Arun District Council
Arun Civic Centre
Maltravers Road
Littlehampton
West Sussex BN17 5LF
Planning & Building Control General Enquiries
Tel: (01903) 737756 Fax: (01903) 730442
Dx: 57406 Littlehampton
Minicom: 01903 732765
e-mail: planning@arun.gov.uk
website: www.arun.gov.uk/planning

Application No: AW/81/21/HH
Site Address: 2 Old Farm Close Aldwick PO21 4AX
Description of works: Two storey extension.

Thank you for your internet representation made on 6th April 2021 which has been recorded as an objection with the comments as follows:

Proposed second floor plan 1:100

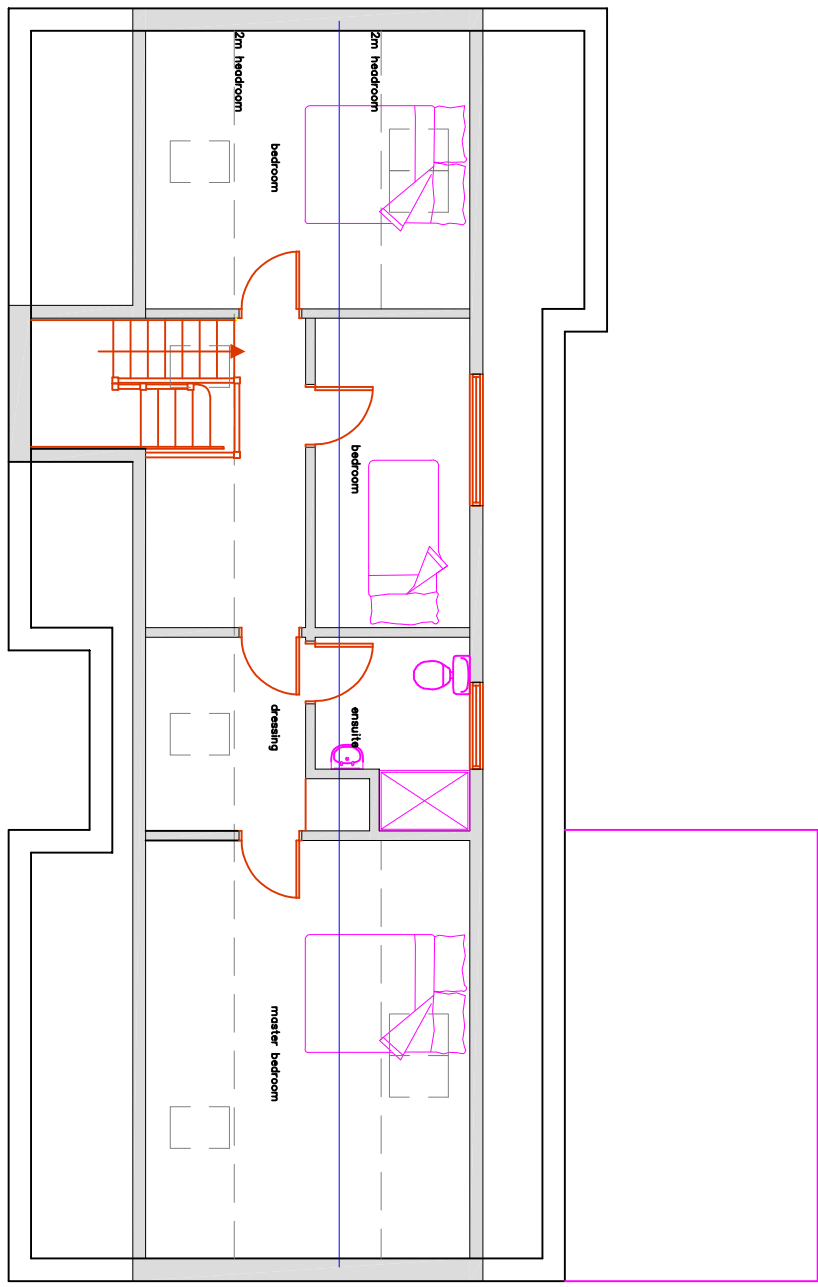
My garden to the west will become overlooked by an additional 2 dormer and 2 velux windows from an elevated vantage on 2nd floor plus new French windows and a balcony from the 1st floor. This is a serious infringement to privacy.

Proposed ground floor plan 1:100

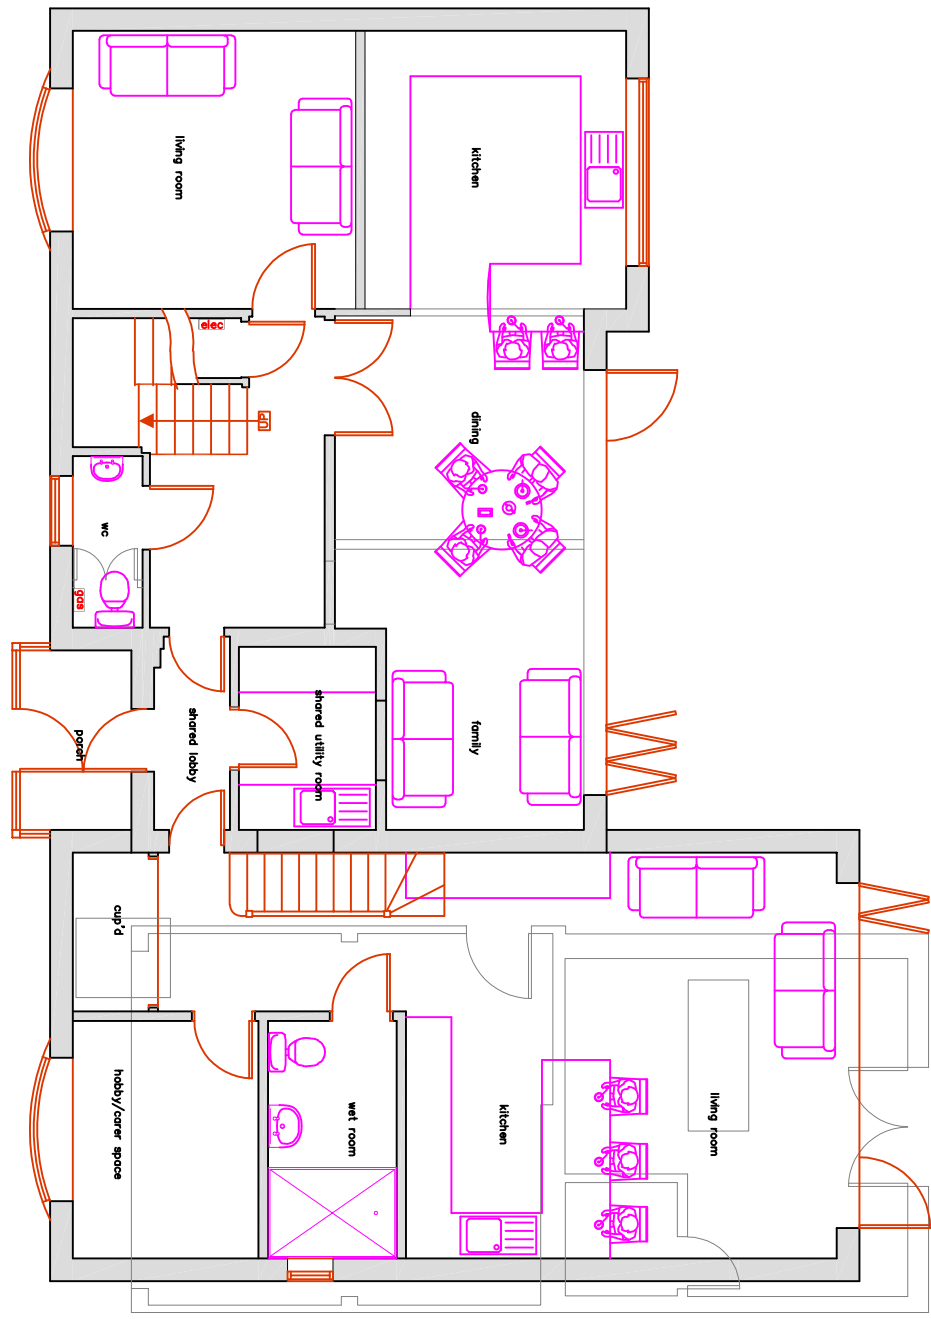
There will no longer be a garage to store a vehicle.

The plans imply that new building works replace an existing part of the dwelling. This is incorrect. The garage and summerhouse are detached and should not be considered as part of the existing living area.
